PLANNING CONSULTATION RESPONSE

Application No	2026/0412
Proposal	Variation of conditions 2 (Approved Plans), 3 (Levels), 4 (Air Quality Mitigation), 5 (Trees), 6 (Highways Adoption Plan), 10 (Cycle Parking), 11 (Noise Mitigation), 13 (Boundary Treatment to Plots 1-7), 15 (CEMP) and 16 (Hampton Windows) of planning application 2021/1405 : Reserved matters (appearance, landscaping, layout and Scale) application for development of 91 homes, structural planting and landscaping, surface water attenuation and associated infrastructure in connection with outline planning permission 2017/1718 (Outline planning for up to 102 homes) (Amended Plans)
Address	Former William Freeman Site, Wakefield Road, Mapplewell, Barnsley, S75 6FZ
Date of Consultation Reply	19 th June 2026
Consultee	Highways DC

Condition 2 (Approved plans)

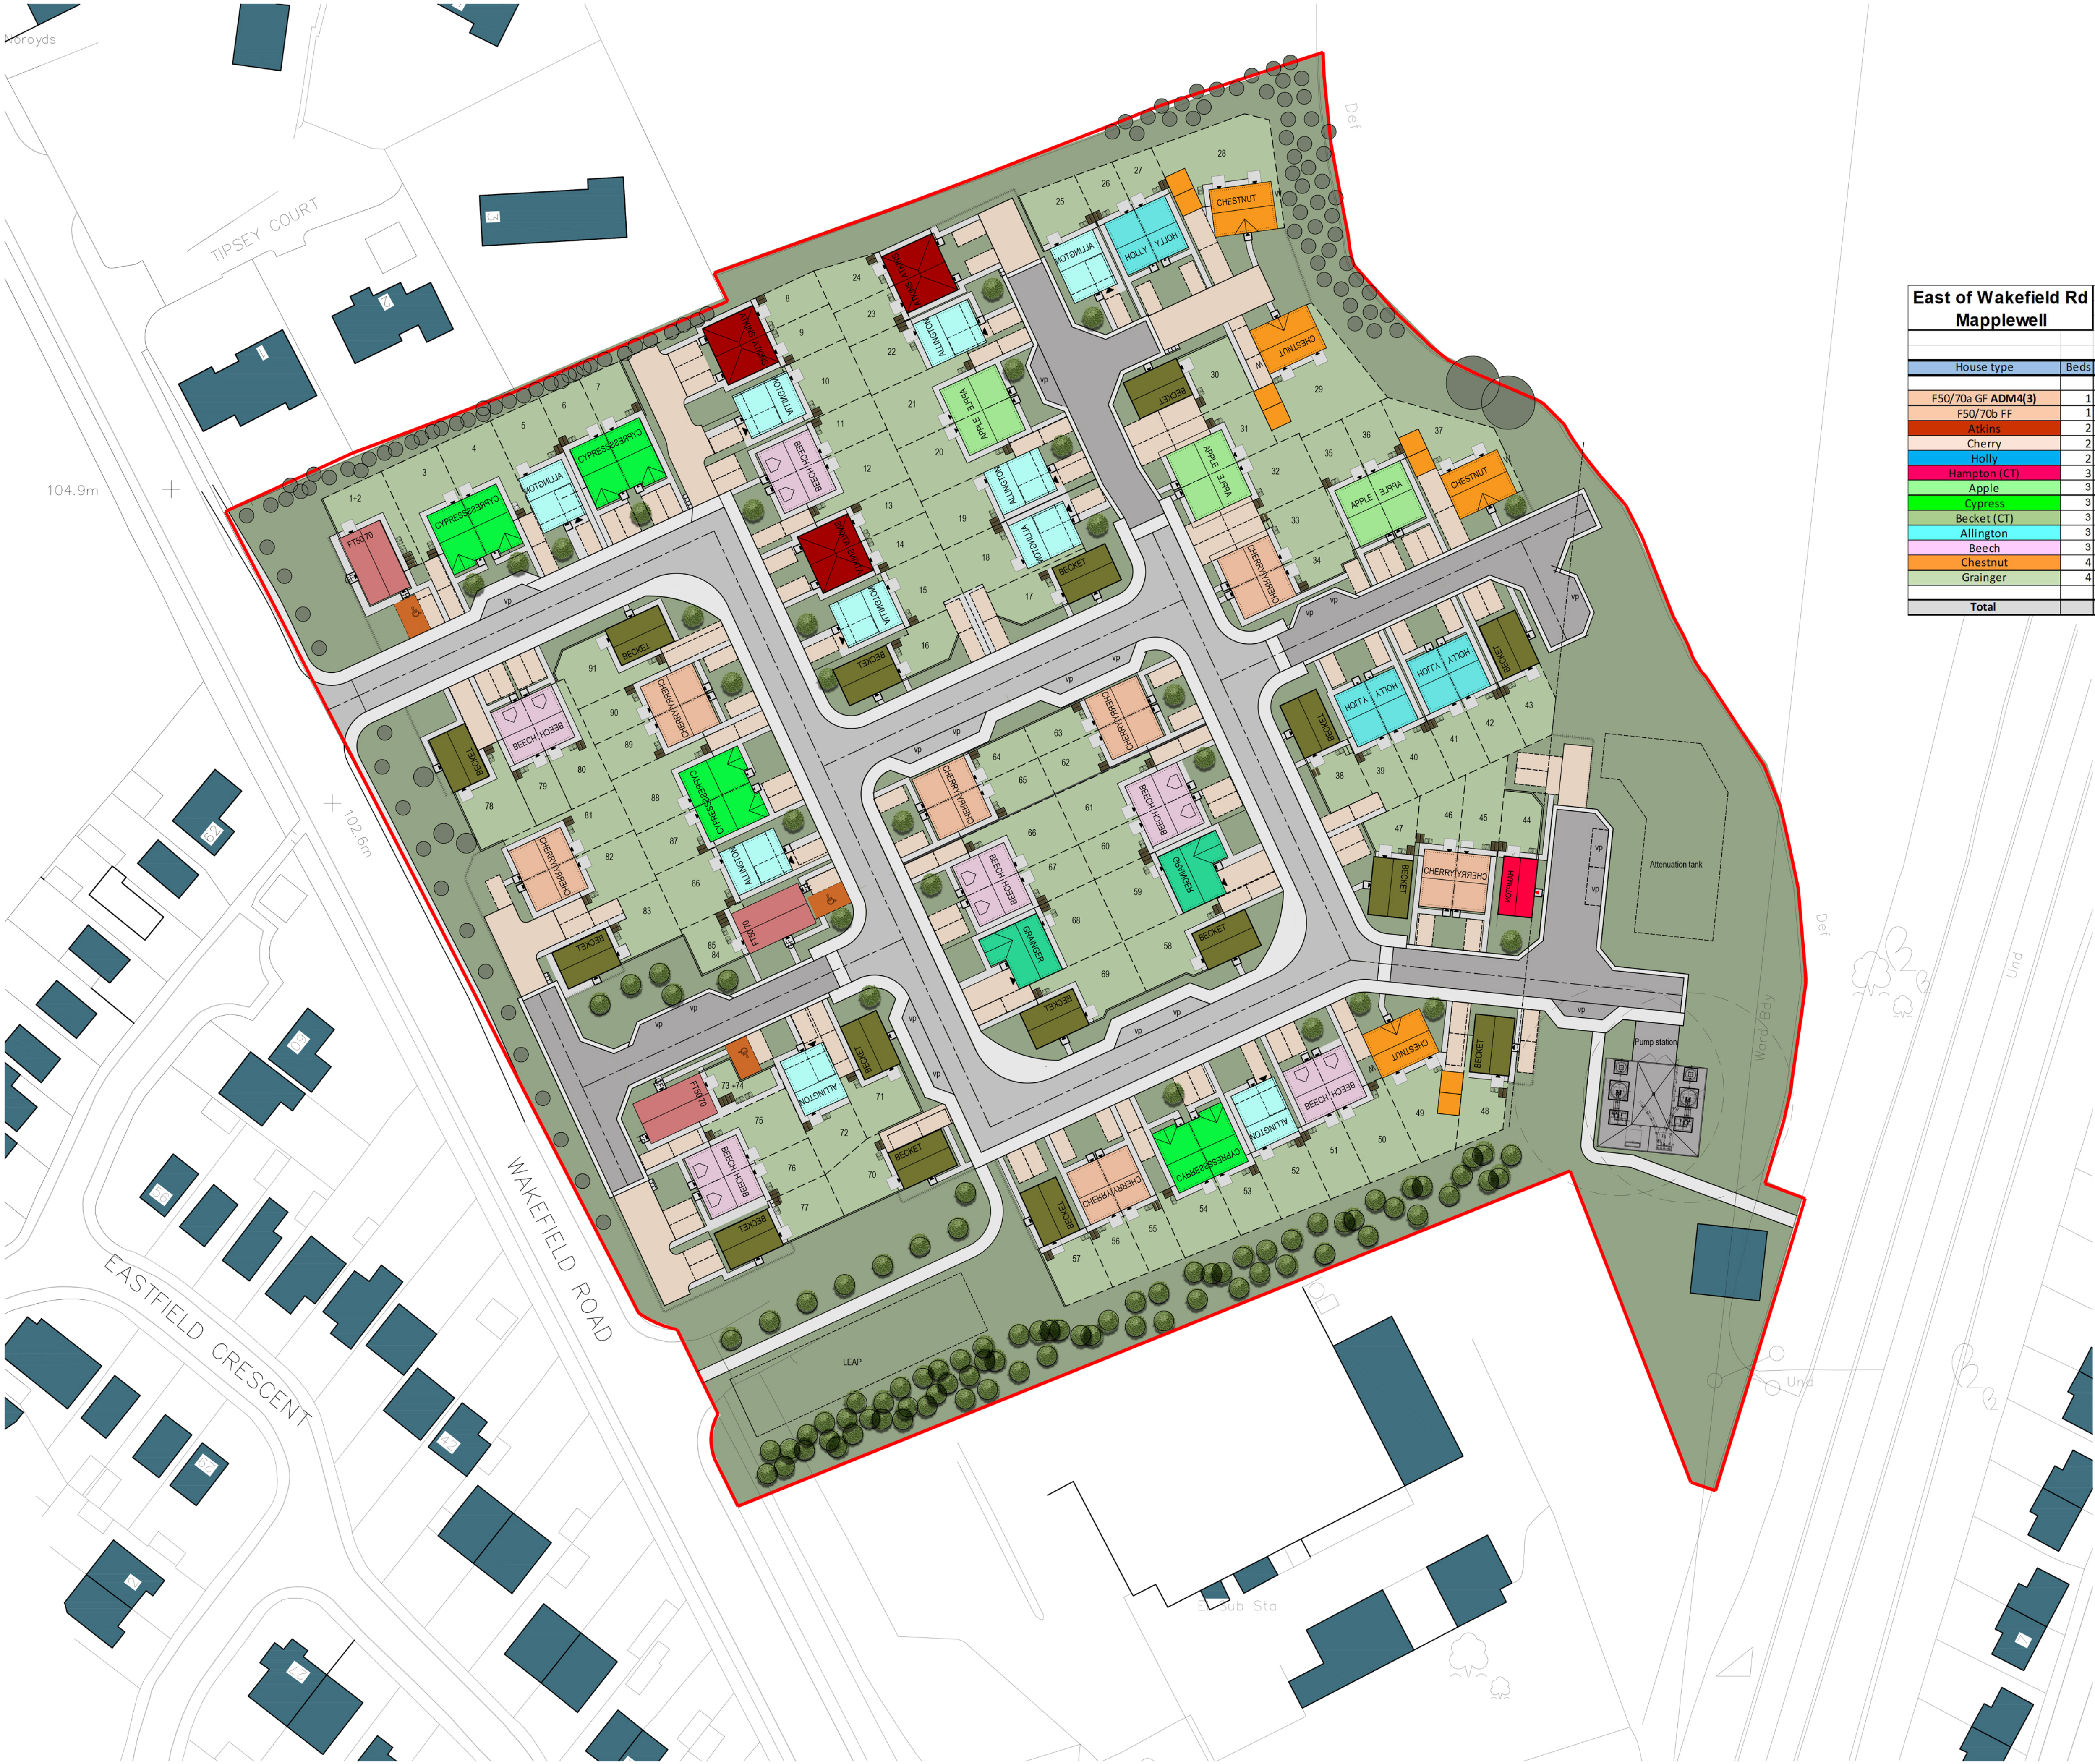
With reference to the amended site layout plans, the following issues need to be addressed:

-The access to Plot 1 is too close to the site access junction with Wakefield Road at a distance of just 14m; there should be no vehicular accesses within 20m of the junction.

-There are no bin collection points shown on the plan; bin collection points should be provided for private drives, within close proximity of the public highway. They should be positioned such that they do not impede visibility or the manoeuvring of vehicles.

-Visitor parking provision appears to have been reduced by five spaces; the number of spaces should therefore be increased to the previously approved number of 19 spaces.

-The driveway of Plot 49 needs to be increased from 5m in length to either 6m if the garage is to have a roller shutter type door or 6.5m for the up-and-over type door.

-Plot 81 does not have adequate turning provision; vehicles would need to reverse approx. 30m in order to access/egress the spaces.

-The turning area adjacent to Plot 43 has been reduced significantly in size from the previously approved layout and there are minor alterations to other turning areas within the site; swept path manoeuvres of refuse vehicles turning throughout the site should therefore be provided.

-The attenuation tank needs to be positioned a minimum distance of 5m from any part of the internal road layout that is to be put forward for adoption to become part of the public highway.
